APPENDIX G INDEPENDENT TRAFFIC ASSESSMENT

Memorandum

To	Amy Watson / Ben Lusher	From	Gillian Austin
Copy		Reference	234109
Date	26 February 2014	Pages (including this page)	7
Subject	Rozelle Village – Review of GTA Response dated 25th February 2014

Swept Path Analysis – Loading Dock

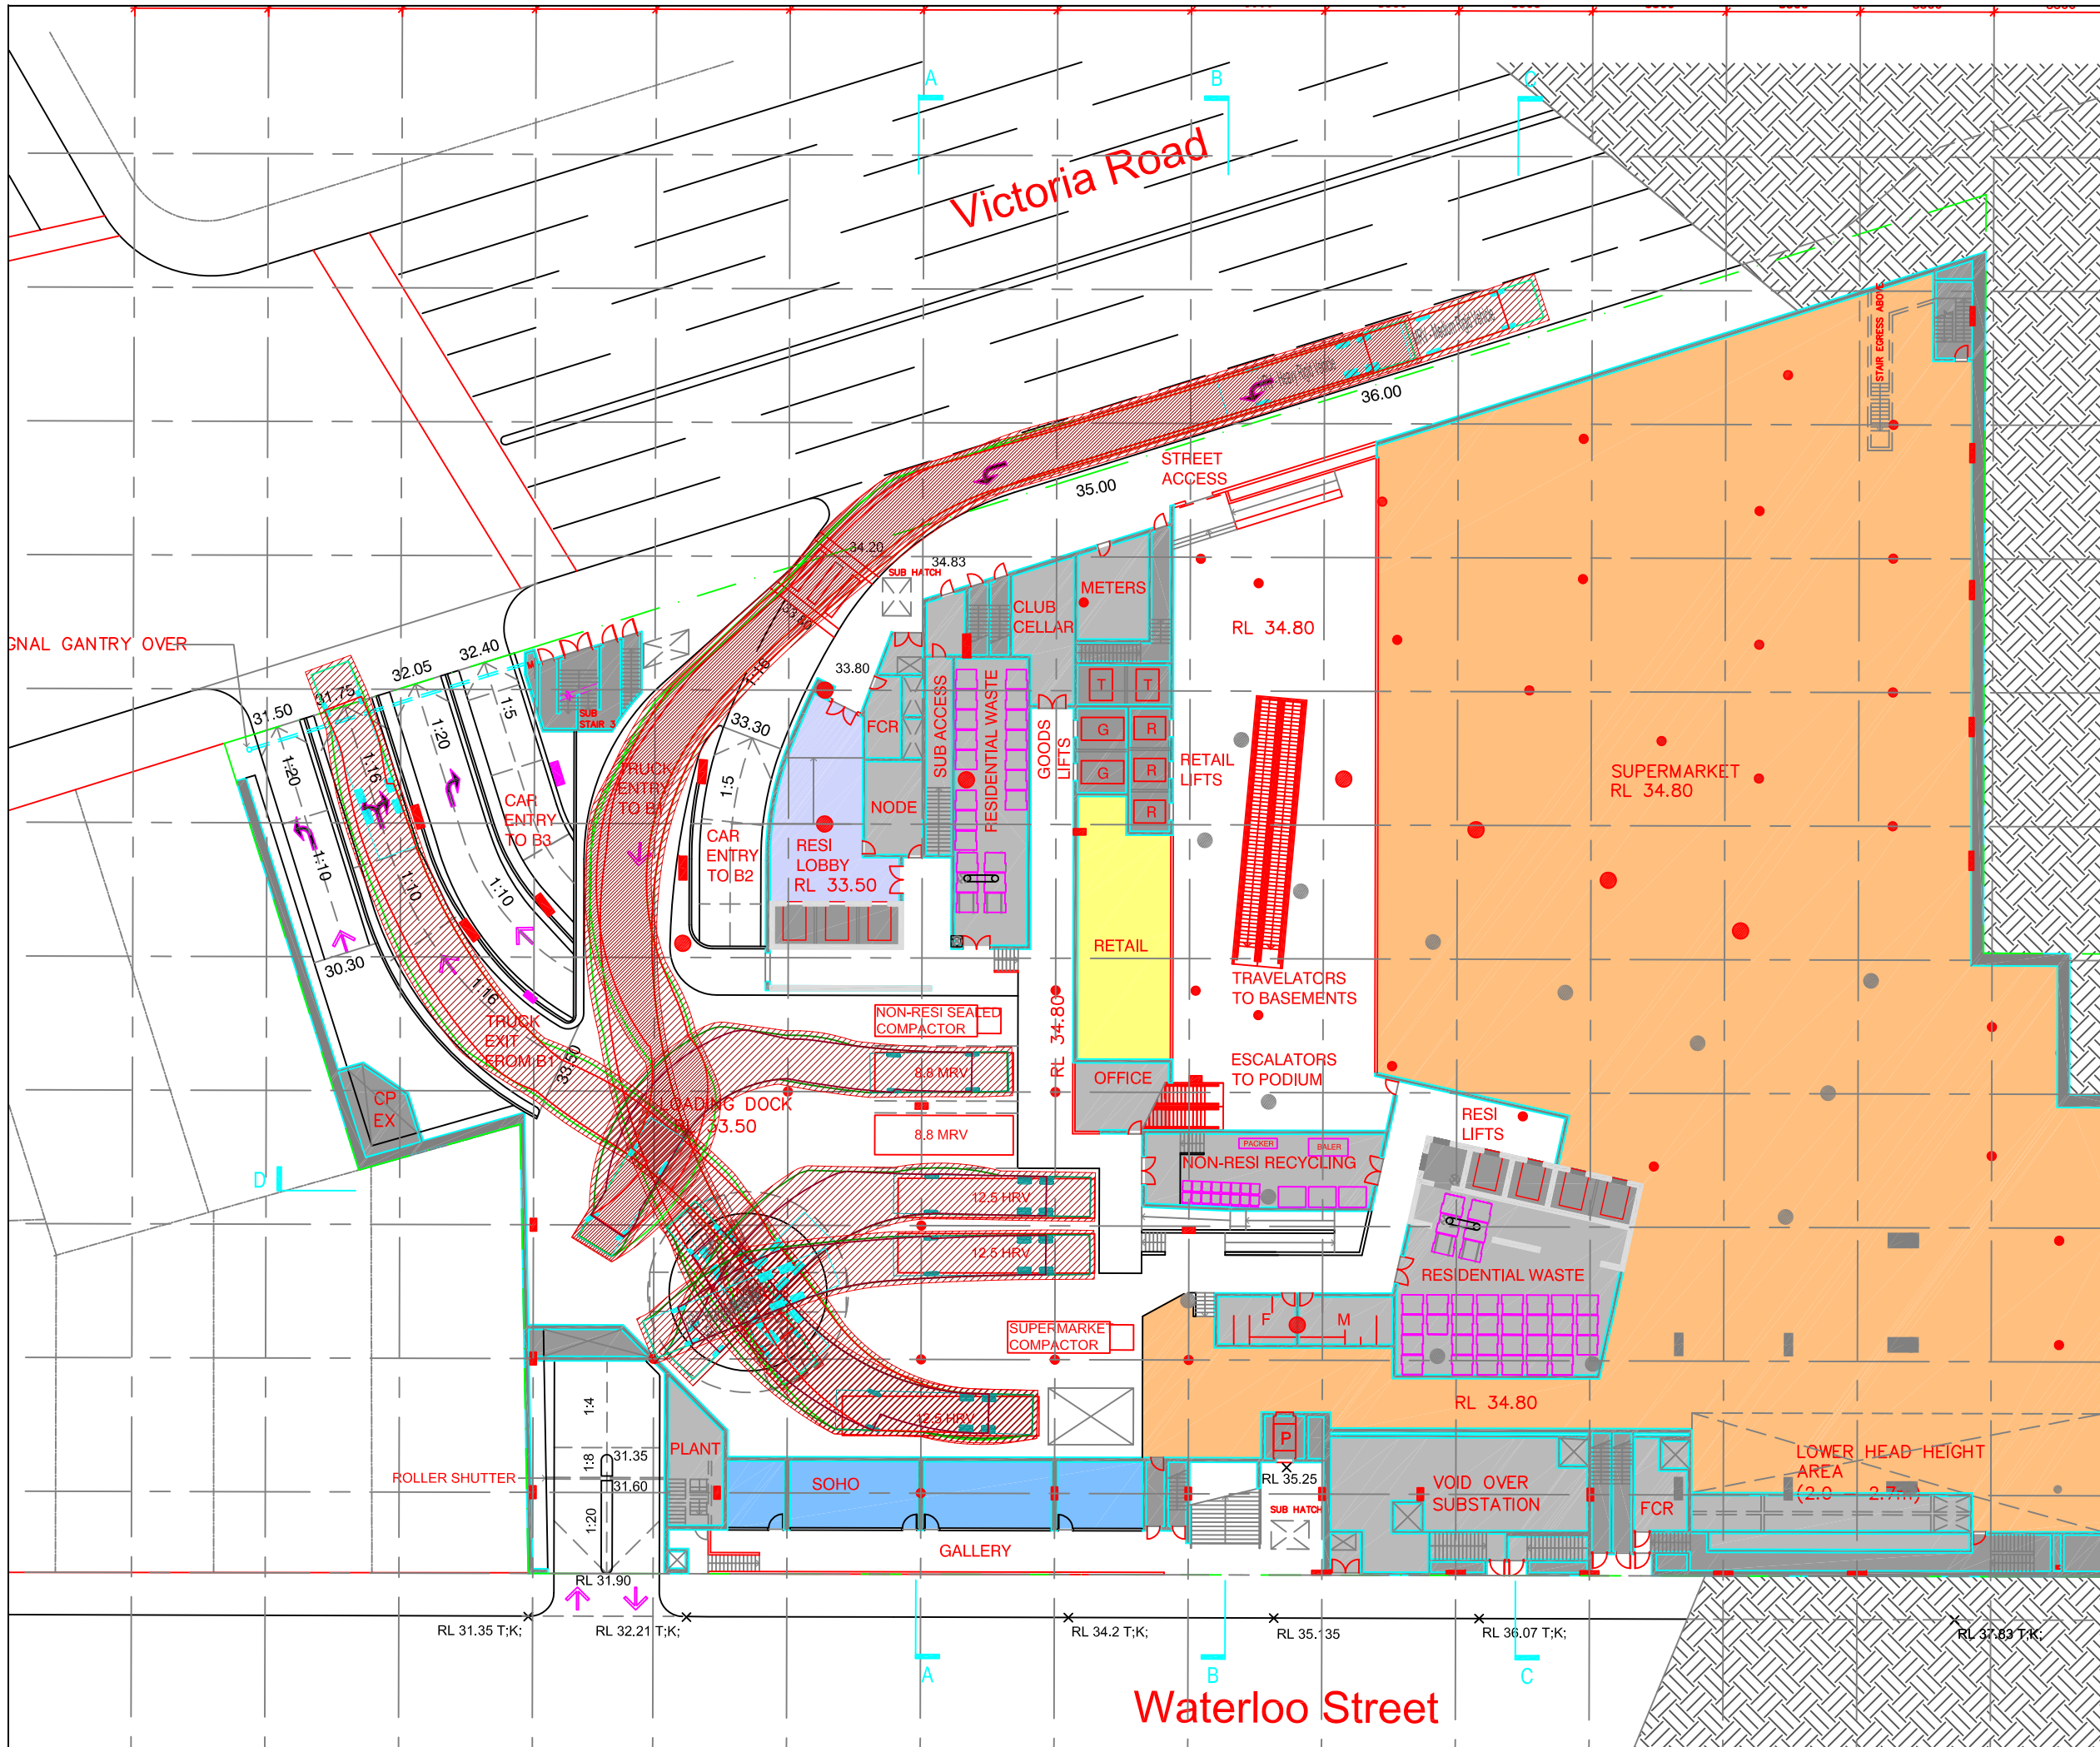
The TfNSW response indicates concerns regarding the effectiveness of the proposed management measures, in particular the proposal to include roller shutter doors on the site access.

Aurecon's view is that whilst there may still be valid issues in relation to the operation of the loading dock access these could be managed by inclusion of appropriate conditions, including but not necessarily limited to include the following:

- No roller shutter door on the heavy vehicle ingress that could prevent vehicles physically entering the loading dock area. This will avoid the scenario of heavy vehicles turning off Victoria Street and not being able to access the service area then reversing back onto Victoria Street;
- Roller shutter door on the exit that can be closed during "loading restriction" preventing vehicles exiting the site and therefore activating the site phase of the signals; and
- Implementation of a delivery management plan prepared to the satisfaction of RMS

Issue potentially could be resolved with suitable permit conditions
